Arun District Council
Arun Civic Centre
Maltravers Road
Littlehampton
West Sussex BN17 5LF
Planning General Enquiries
Tel: (01903) 737756 Fax: (01903) 730442
Dx: 57406 Littlehampton
Minicom: 01903 732765
e-mail: planning@arun.gov.uk
website: www.arun.gov.uk/planning

07 August 2015

Town & Country Planning Act 1990 (as amended)
Town and Country Planning (Development Management Procedure) (England) Order 2015
Application for approval of matters reserved by conditions imposed under LU/385/14/PL relating to
condition No's 3, 8, 10, 11 & 12 - Solar Farm Materials, Landscaping Scheme, Traffic Management
plan & SHE Quality plan.
Land at Brook Barn Farm Courtwick Lane, Littlehampton,

Pic.3 Parking and welfare layout

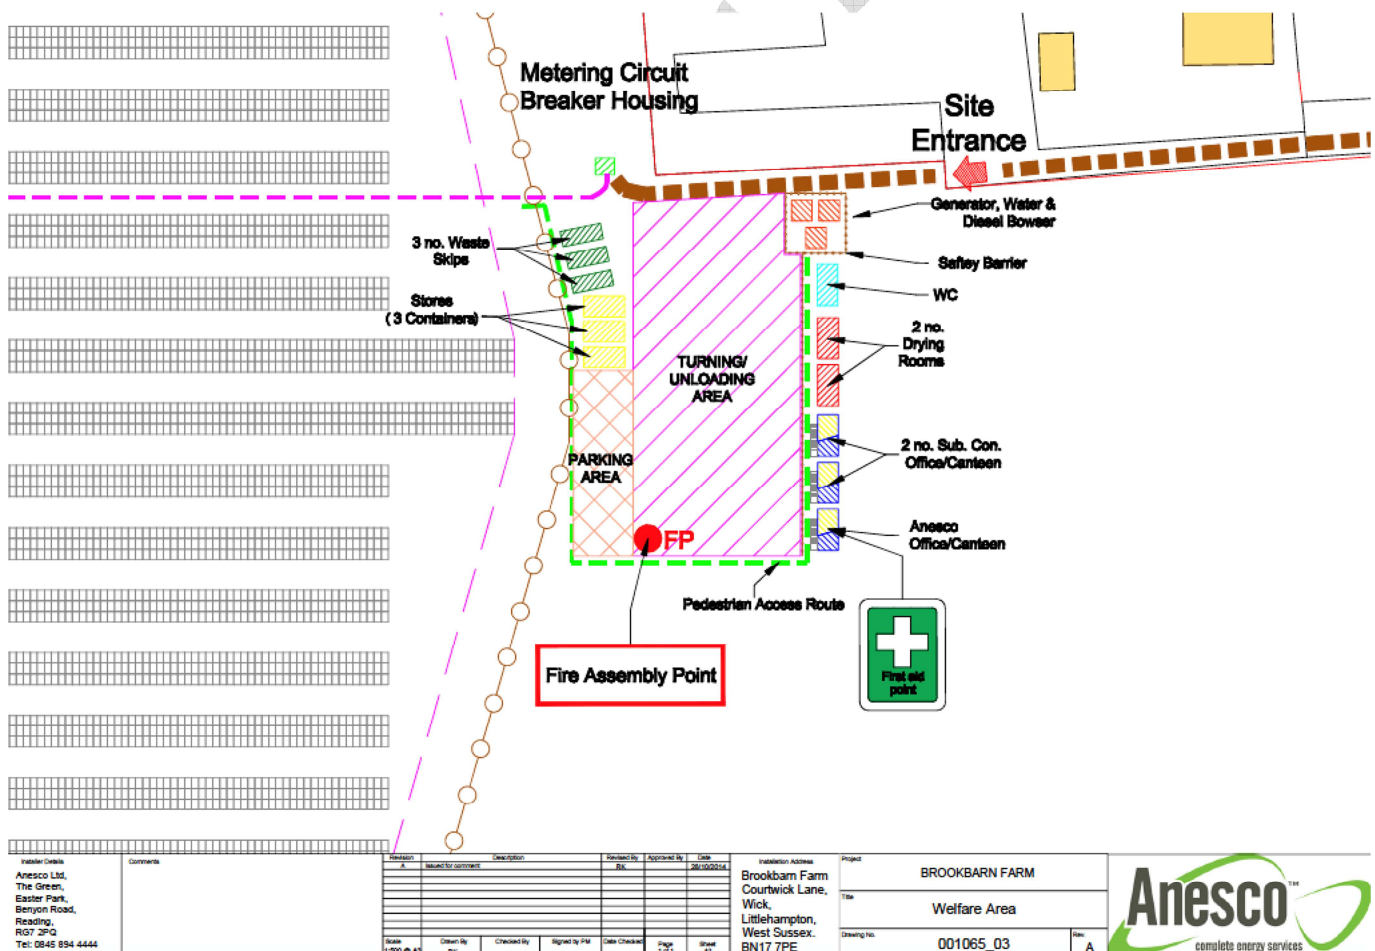
Arun District Council have decided to **APPROVE details reserved by this condition**
The Applicant has confirmed that there will be no reversing manoeuvres undertaken by HGVs within Old Mead Road. Plan 001453_03 Welfare Area_RevC includes an on-site turning area for large vehicles which must be kept clear of other vehicles/equipment at all times.
